Householder Proforma

Application Ref: 2021/1392

Address: 10 Summerford, Ingbirchworth, Sheffield, S36 7GS

Proposed: Erection of rear extension and external works including alterations to boundary fence

Project.	10 SUMMERFORD INGBIRCHWORTH SHEFFIELD S36 7GS	Client.	
Drawing Title.	SITE PLAN AS PROPOSED	Date.	OCT. 2021
		Scale.	1:100 @ A3
		Ref.	102-129
		Dwg. No.	04
		Rev.	A

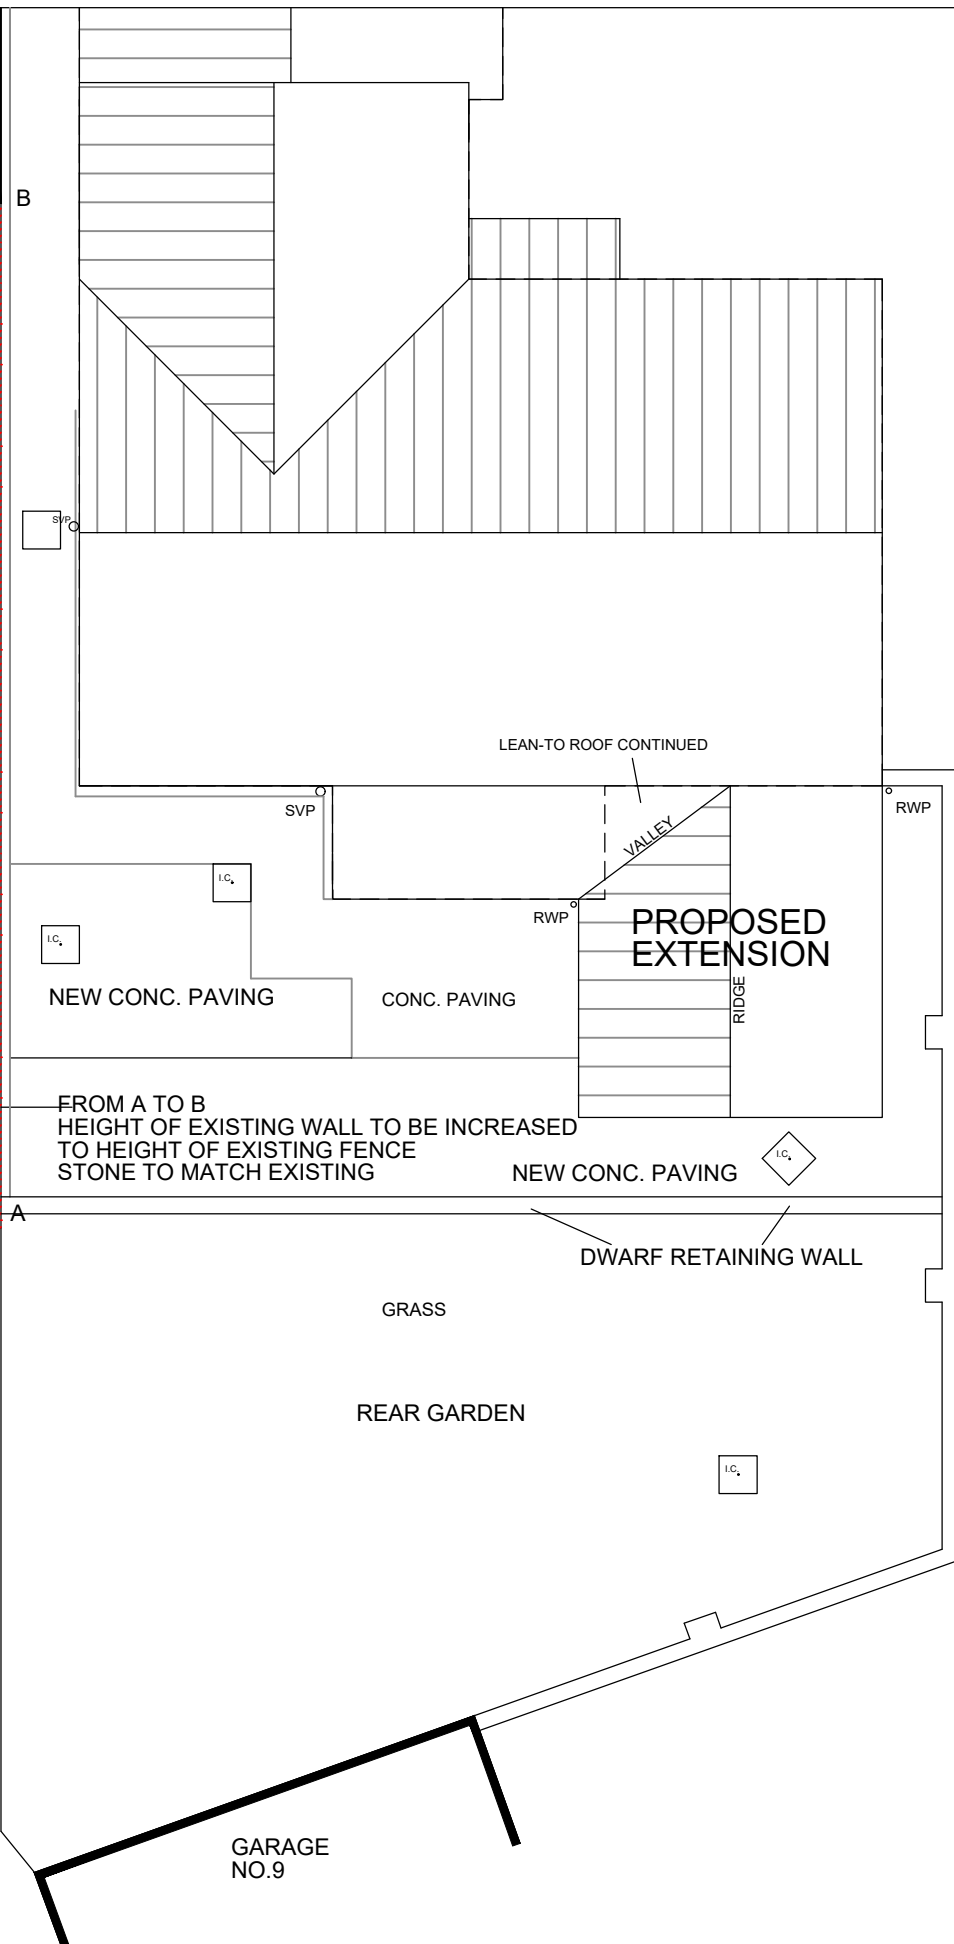
The proposal is for the erection of a single storey rear extension to the property, located to the side of the existing. The extension will project 4.385m and measure 4.016m in width, 2.41m to the eaves and 3.64m total height. The roof will be pitched and tie in with the existing lean to, the materials will be in matching stone and tile.

9. distance to rear boundary (shared with another residential property) 10m or more?	Less than 10m, approximately 6m distance from the rear boundary. Mitigating factors, the rear boundary is a sufficient height to provide privacy, beyond and forming part of the rear boundary is the neighbouring garage and driveway, therefore privacy is not expected to be compromised.

Project.	10 SUMMERFORD INGBIRCHWORTH SHEFFIELD S36 7GS	Client.
Drawing Title.	WALL TO REPLACE FENCING	Date. OCTOBER 2021
		Scale. 1:50 @ A3
Ref.	102-129	Dwg. No. 05
		Rev.

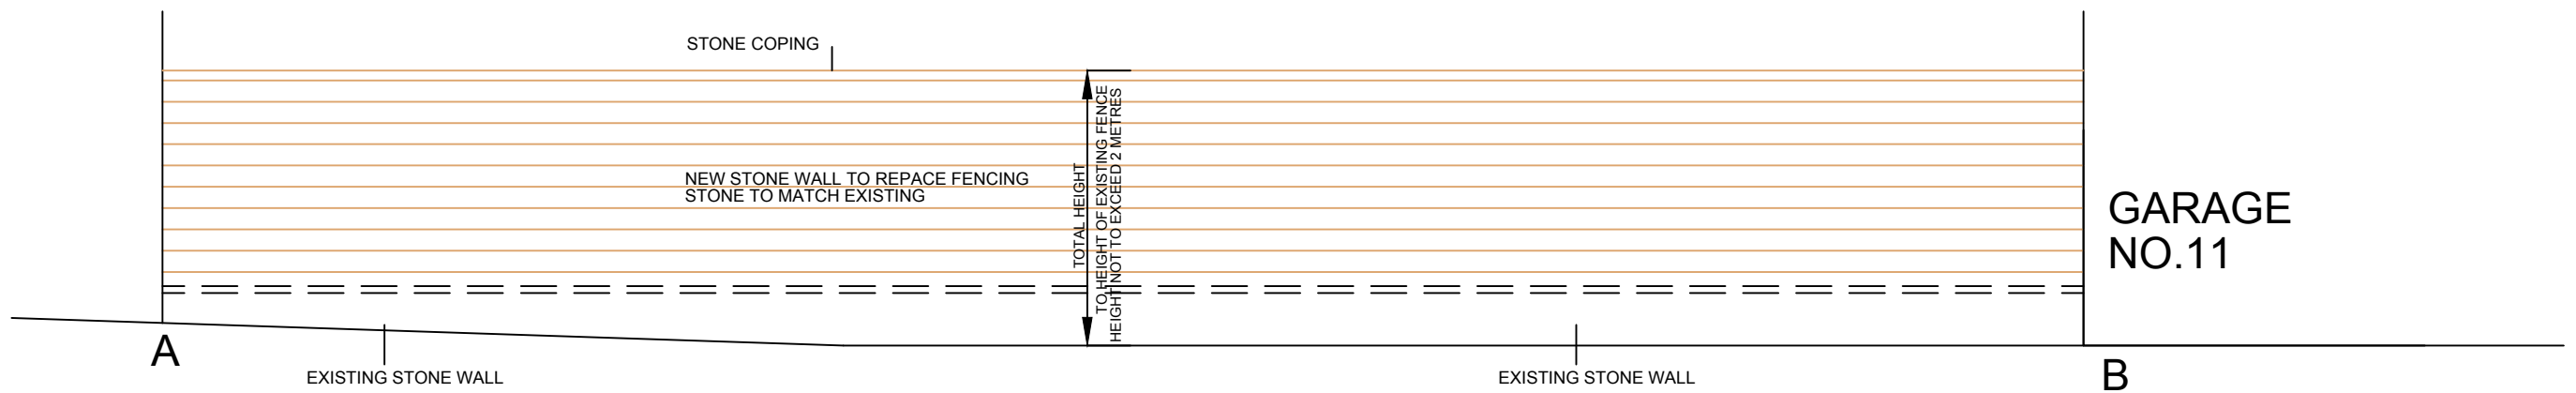
The proposal is also to replace the existing wooden fence with a continuation of the existing stone boundary wall. This will run to the rear of the garden at number 12. The wall will not measure more than 2m in height.

The single storey rear extension is in line with planning policy in terms of size, design, materials, and proportions. The proposed wall will be no higher than 2m, will replace an existing fenced boundary of a similar height, therefore is not expected to cause any detriment to the residential amenity currently enjoyed by neighbouring properties. As the proposed wall is 2m in height and replacing an existing boundary fence in-between the gardens of neighbouring properties and not adjacent to a highway and permitted development rights have not been removed for this property, formal planning permission is not required.

8. habitable room windows on the side elevation?	Yes, side patio doors leading into the rear garden at ground floor level. The proposed boundary wall will provide a sufficient screen from the adjoining garden and neighbouring property.
